# MIDDLETON STONEY ROAD, BICESTER.

## PROPOSED PHASE 1B WORKS

### Stage 1 Road Safety Audit

**SG-AA-2024-4431-RSA1**

TITLE  
PHASE 1B REFUSE & LARGE CAR TRACKING  
SHEET 1 OF 2

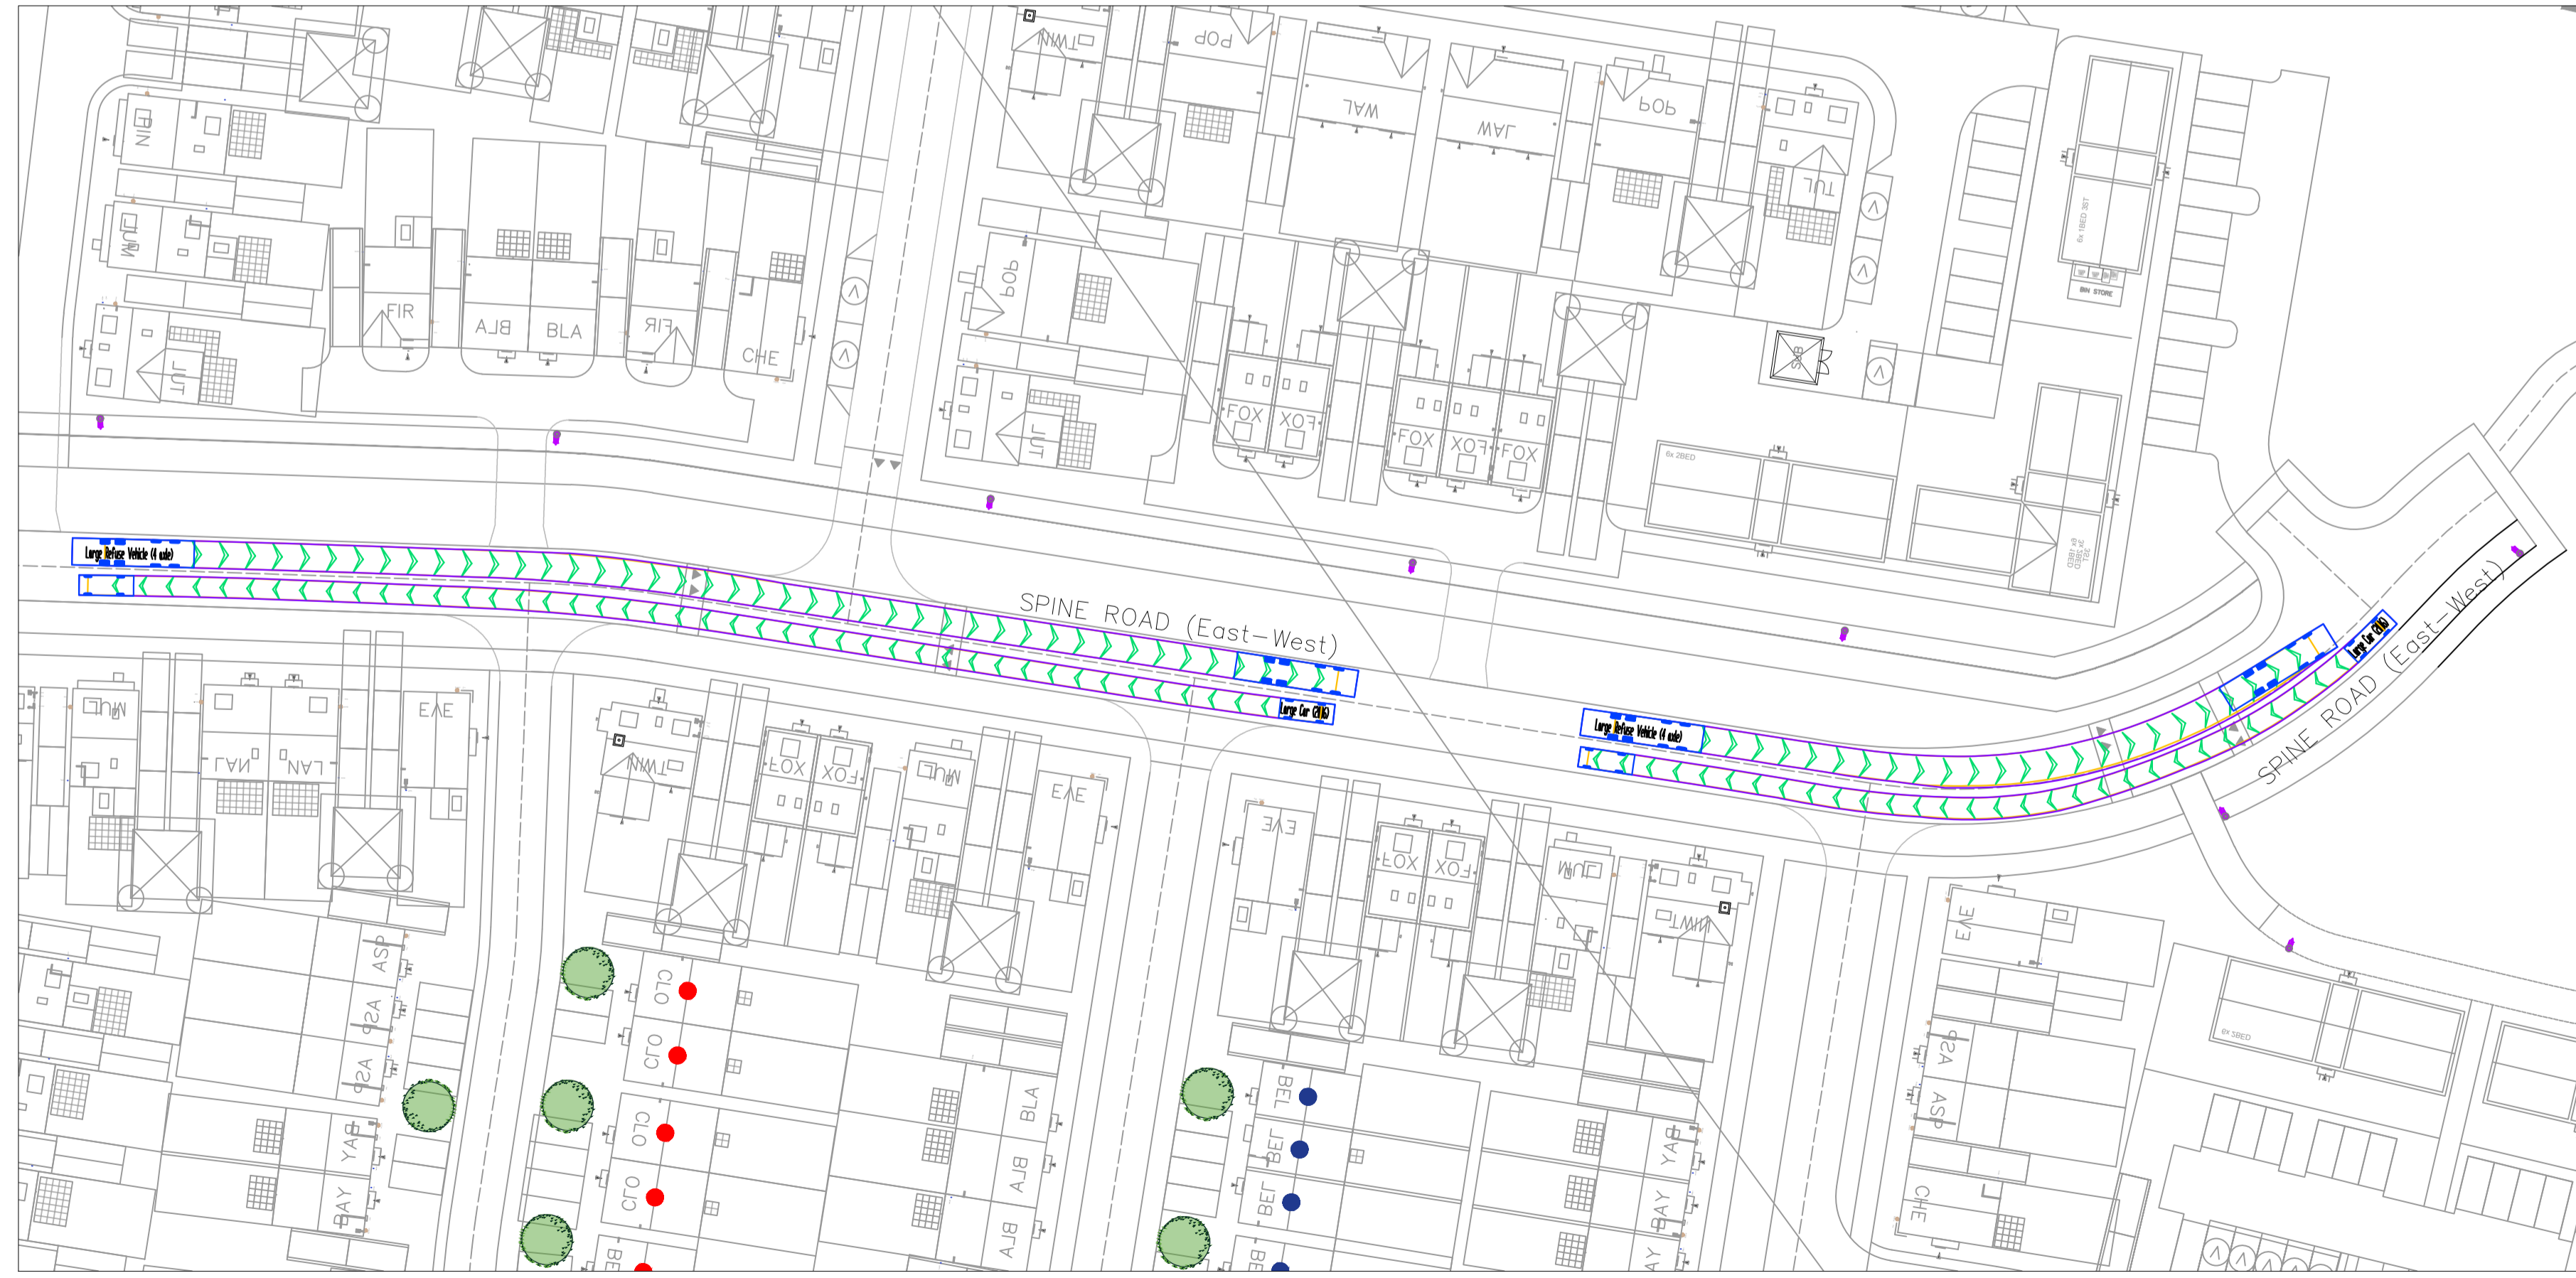
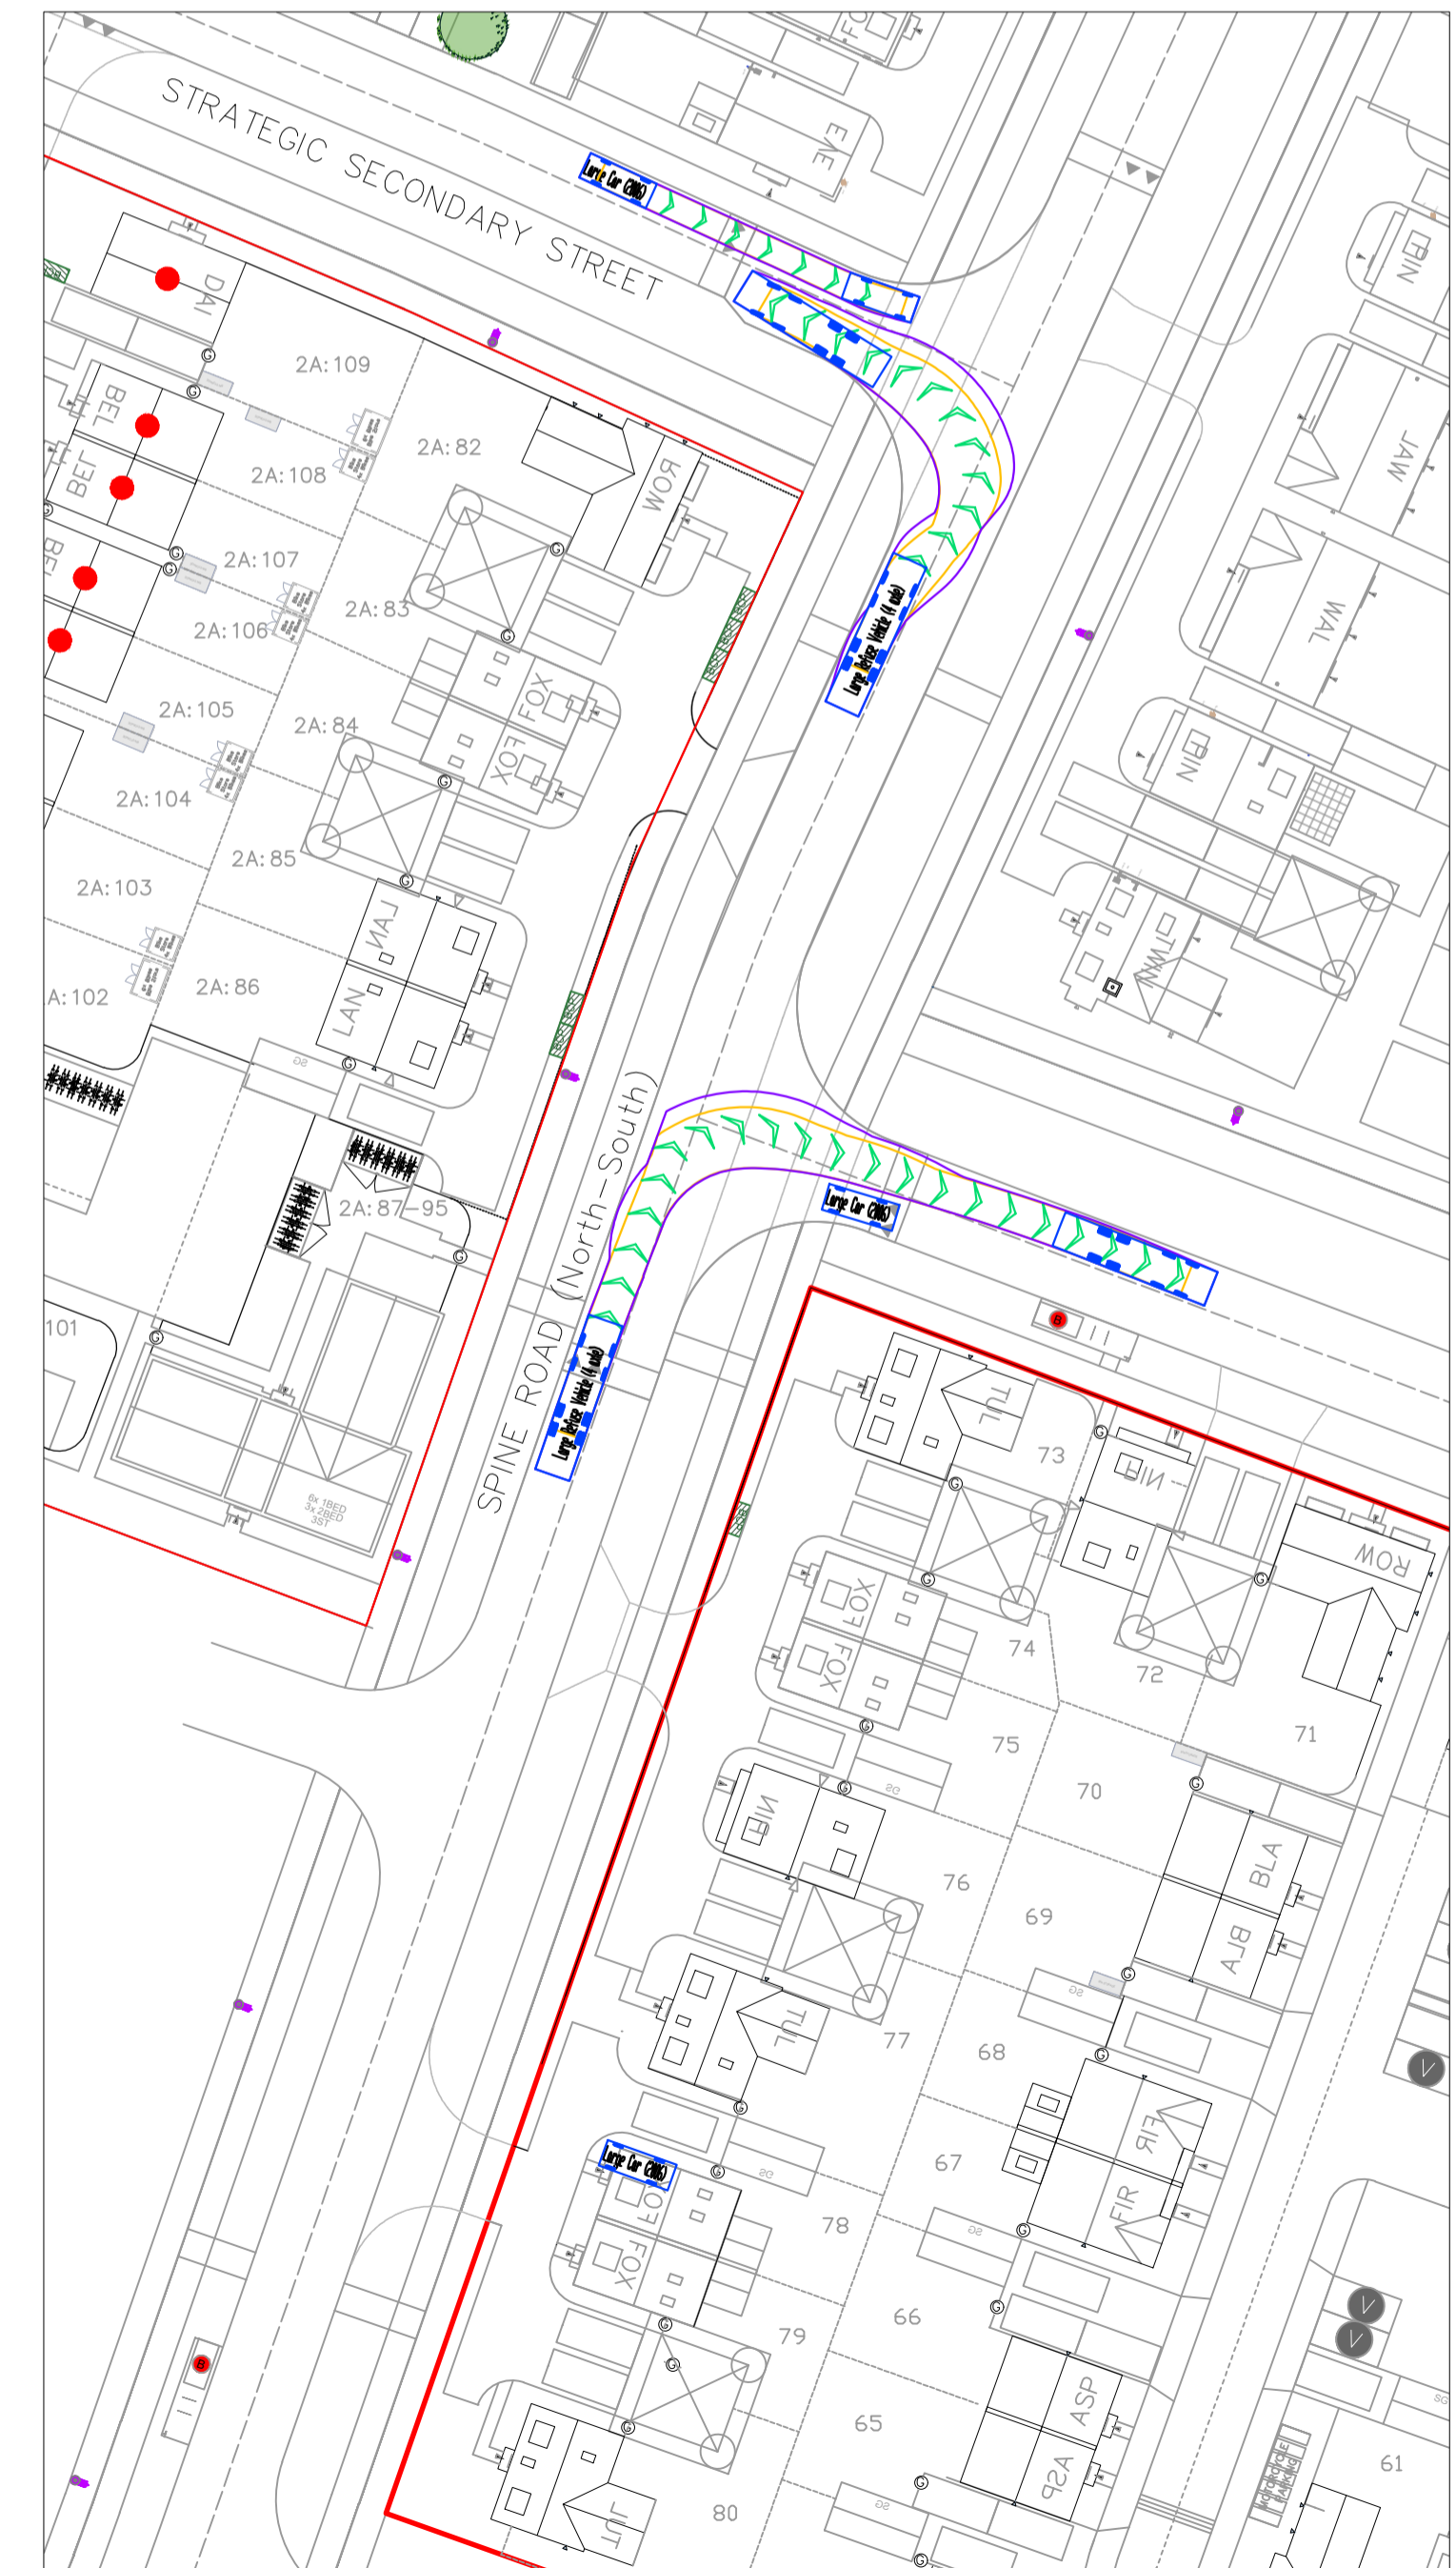
From the vehicle swept path analysis provided as part of the scheme submission, it is evident that larger service/refuse vehicle cannot turn left from the site without encroaching onto the right turn lane. Insufficient carriageway widths to accommodate long wheel based vehicular turning movements may increase the risk of vehicle on vehicle side impact/sideswipe type collisions.

The Audit Team recommends providing adequate carriageway geometry to ensure that all likely vehicle types to use this junction can carry out turning safely and without obstruction.
